From: Kate MacDonald
Sent: Monday, 14 December 2015 4:06 PM
To: Thomas Piovesan
Subject: FW: NSW Planning & Environment - SSD 6917 Notice of Exhibition RE Oakdale South Industrial Estate Erskine Park Penrith

From: Andrew Worboys [<mailto:Andrew.Worboys@endeavourenergy.com.au>]
Sent: Monday, 14 December 2015 3:39 PM
To: Kate MacDonald
Cc: Jason Lu; Cornelis Duba
Subject: NSW Planning & Environment - SSD 6917 Notice of Exhibition RE Oakdale South Industrial Estate Erskine Park Penrith

I refer to the letter from NSW Planning & Environment received on 13 November 2015 regarding SSD 6917 Notice of Exhibition for the Oakdale South Industrial Estate, off Milner Avenue, Erskine Park, Penrith LGA (Lot 12 DP 1178389, Lot 87 DP 752041) for 'Creation of a warehouse and distribution hub comprised of 15 building envelopes across 6 development precincts with a maximum gross floor area of 395,880 m2'

GENERAL ARRANGEMENT PLAN

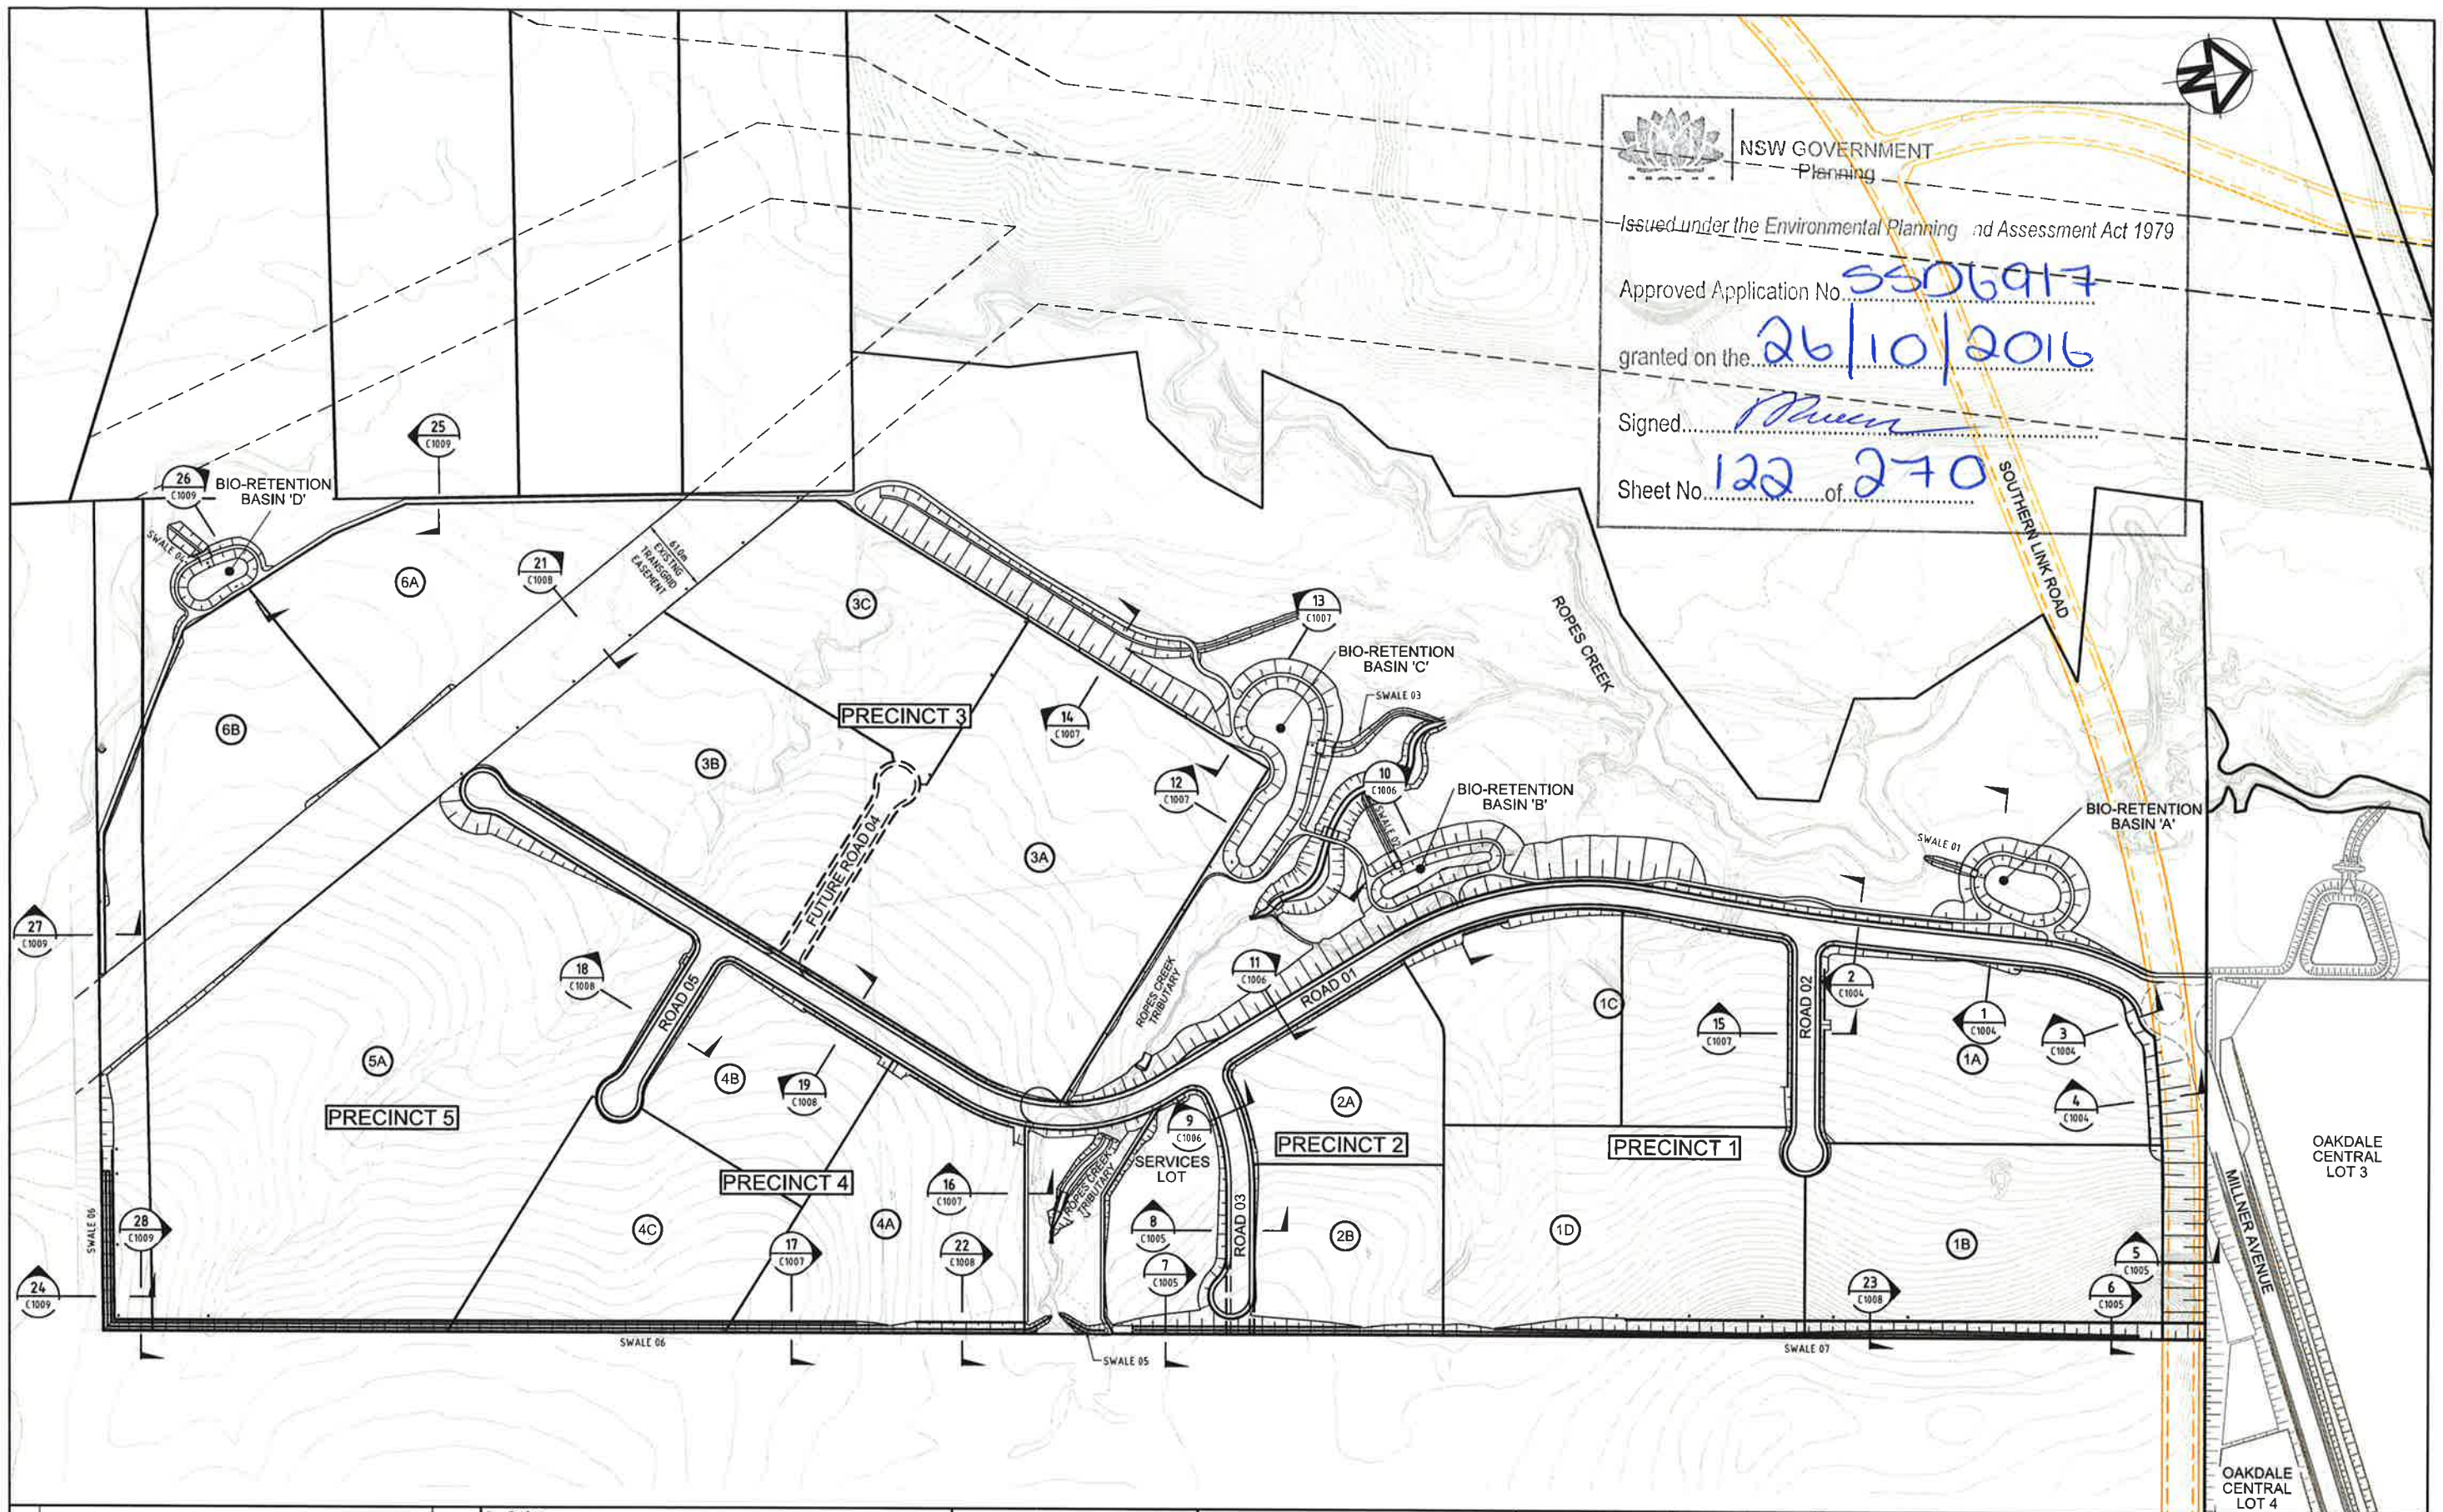
The Oakdale South precinct is isolated from Oakdale West and Erskine Park, making it difficult to extend existing infrastructure. It would be Endeavour Energy's preference that the link East/West link road is established earlier to enable provision of infrastructure or a services corridor established to link Oakdale South and Oakdale West.

1. Initial supply will be from Eastern Creek ZS
2. Allowance to be made in the Oakdale South indicative plan for the continuation of distribution ducts into Oakdale West subdivision road pattern.
3. Future establishment of a Zone Substation Site once supply from existing sources is exhausted.
4. Consideration needs to be given to a 132kV transmission line route back to Sydney West BSP
